# CITY OF MERCER ISLAND

RE: Request for Information #1 for File No. SUB21-006, CAO21-004, SEP21-022 – Milestone Short Subdivision  
7621 SE 22<sup>nd</sup> ST, Mercer Island, WA 98040; King County Tax Parcel # 531510-1846

The City of Mercer Island received the resubmittal for SUB21-006 on September 1, 2021 addressing the Incompleteness Letter dated 7/20/2021. In addition, the City of Mercer Island received the submittal for a Critical Areas Review 2 (CAR2) application and SEPA Review application on September 1, 2021. The CAR2 application was assigned application #CAO21-004 and the SEPA Review application was assigned #SEP21-022. The applications were determined to be complete on October 21, 2021. Following review of the applications listed above, City staff has determined that additional information is necessary to ensure compliance with the Mercer Island City Code (MICC). Please note that further review of this application is on hold until the following information is provided by the applicant (application status is "WCI" Waiting Customer Information). Please provide the following items:

SHEET 2 OF 4

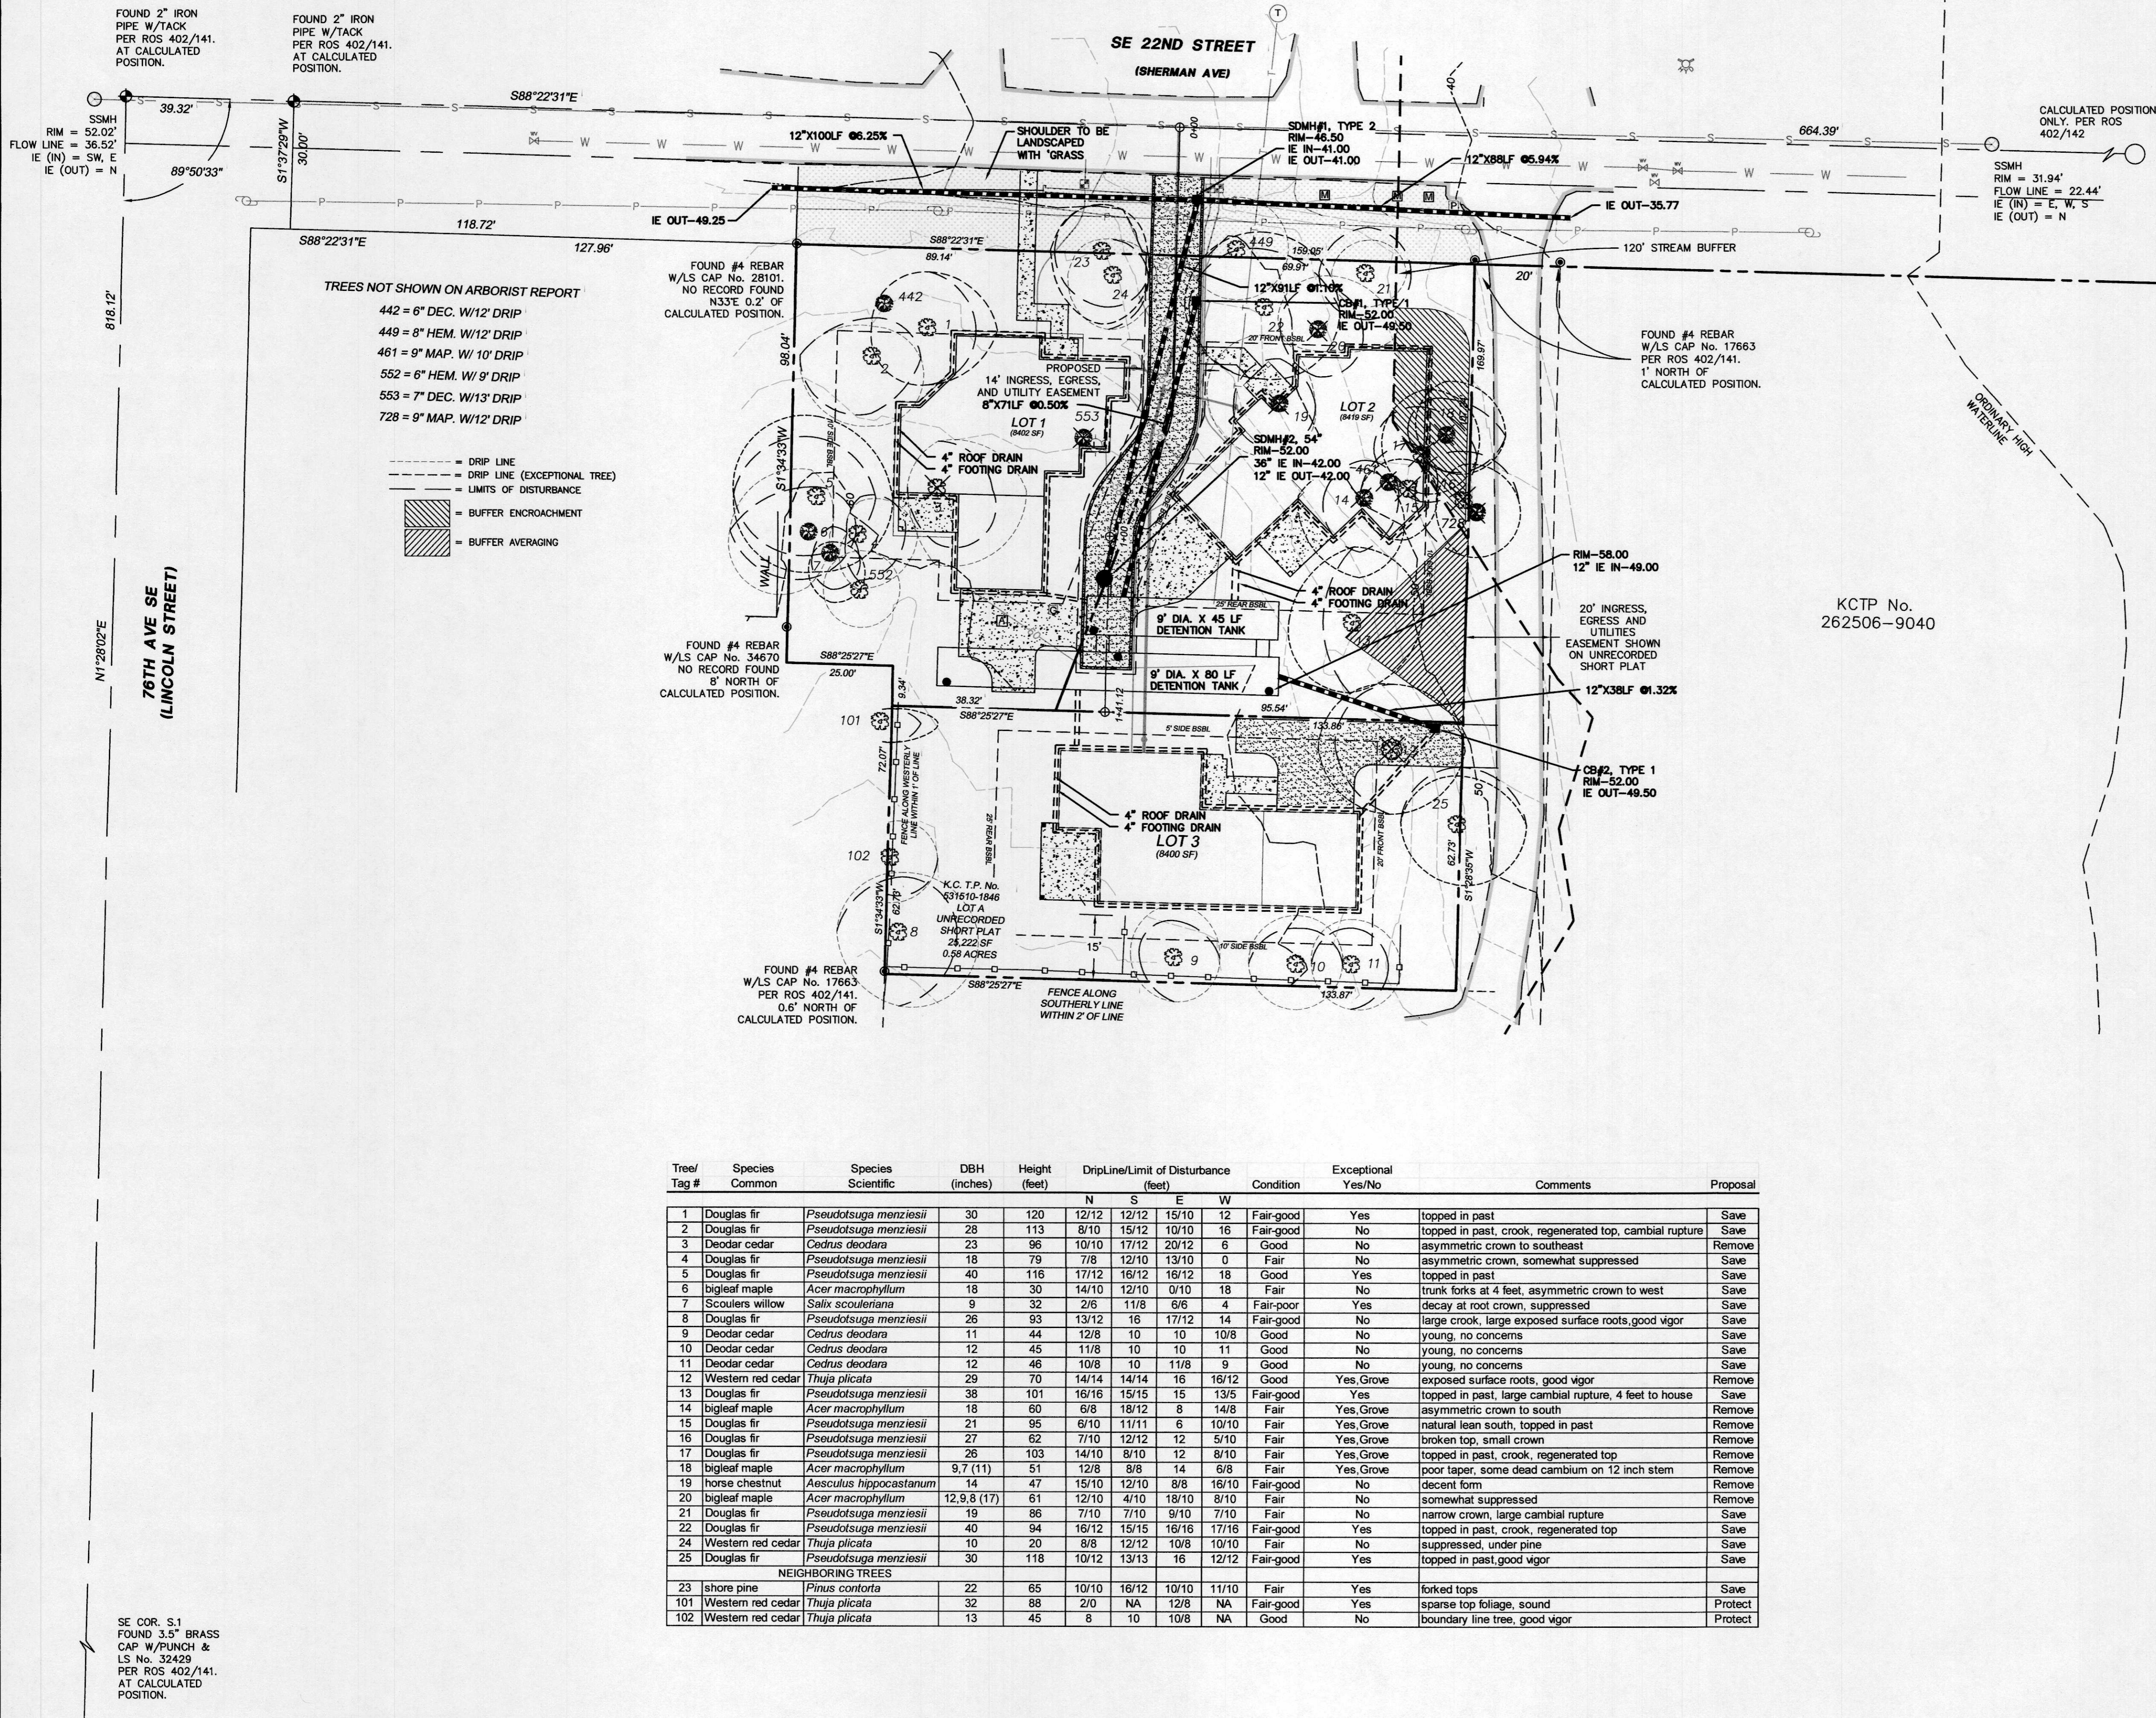
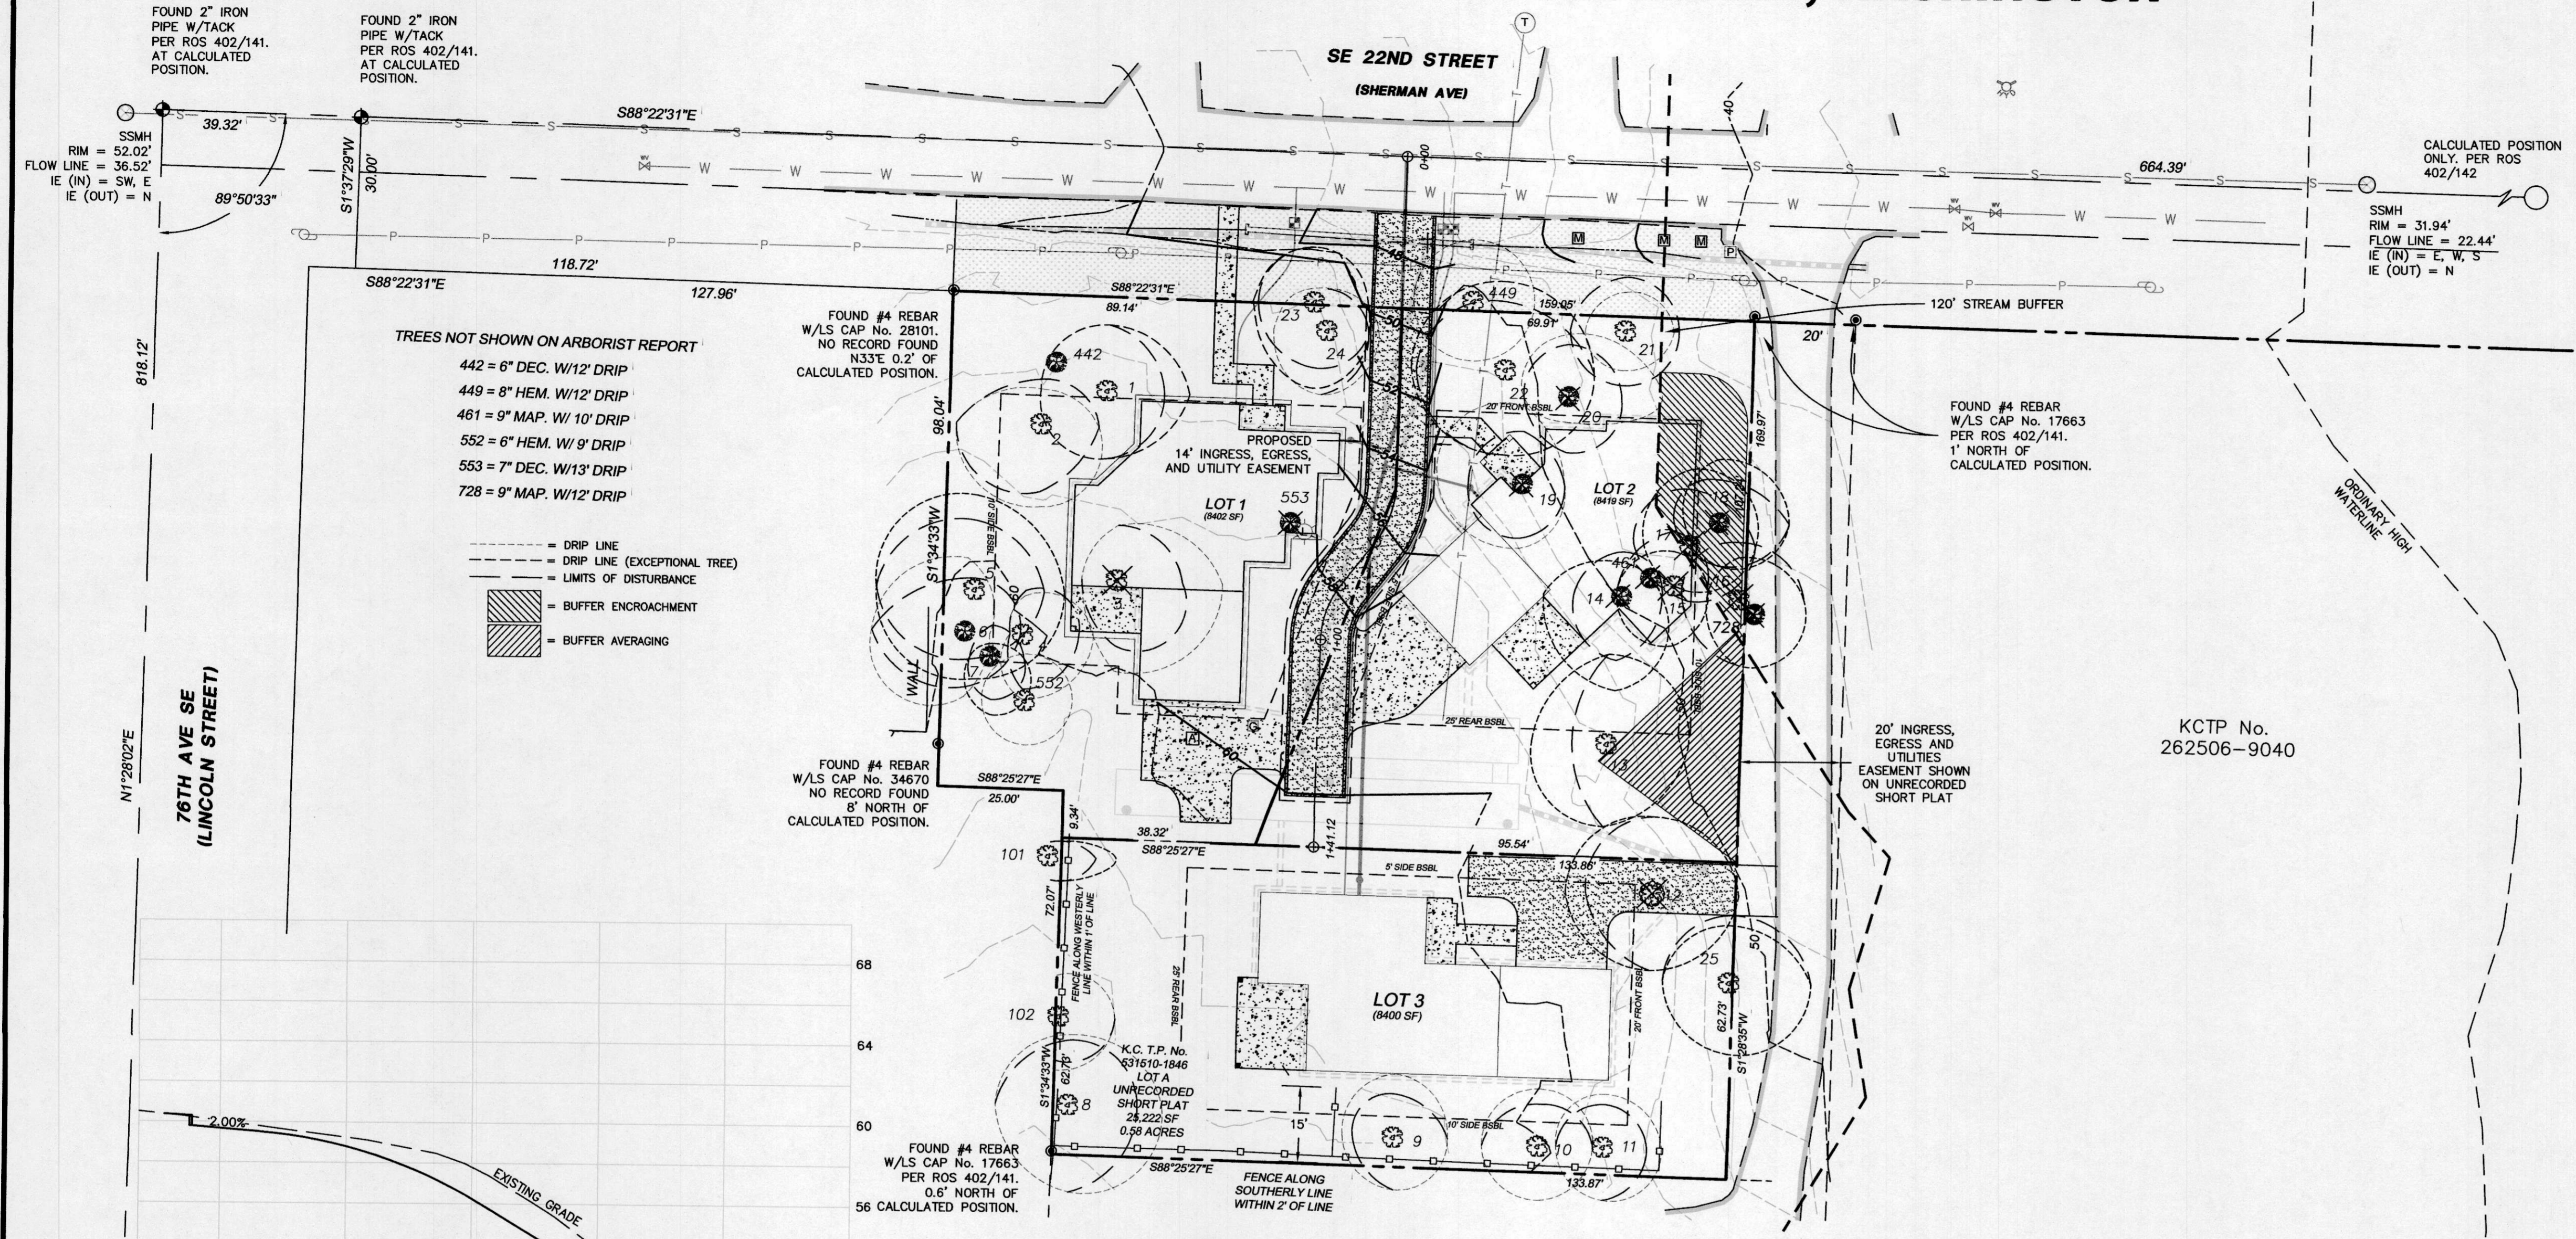
12. (For Architect from Pre application meeting/Intake) Tree 13 is exceptional and dripline is not shown according to Arborist report. A 16' dripline to the north should be shown. Also see the Arborist's Limits of allowable disturbance that must be shown on the plans and updated for all trees. If these limits are encroached upon the tree would be considered damaged and possibly removed. Unless an Arborist supervised, and controlled air excavation root analysis is conducted and finds different results. Example, exceptional tree 1 is shown 2' from a building pad. This tree would need to be removed as shown and would need justification per MICC19.10.060.3. Or move the building pad with at least 5' surrounding the building pad for access.

15. You will be required to save 30% of all large regulated trees and any exceptional trees over 24" in diameter. Please provide a plan with these trees indicated along with their Arborist given driplines.
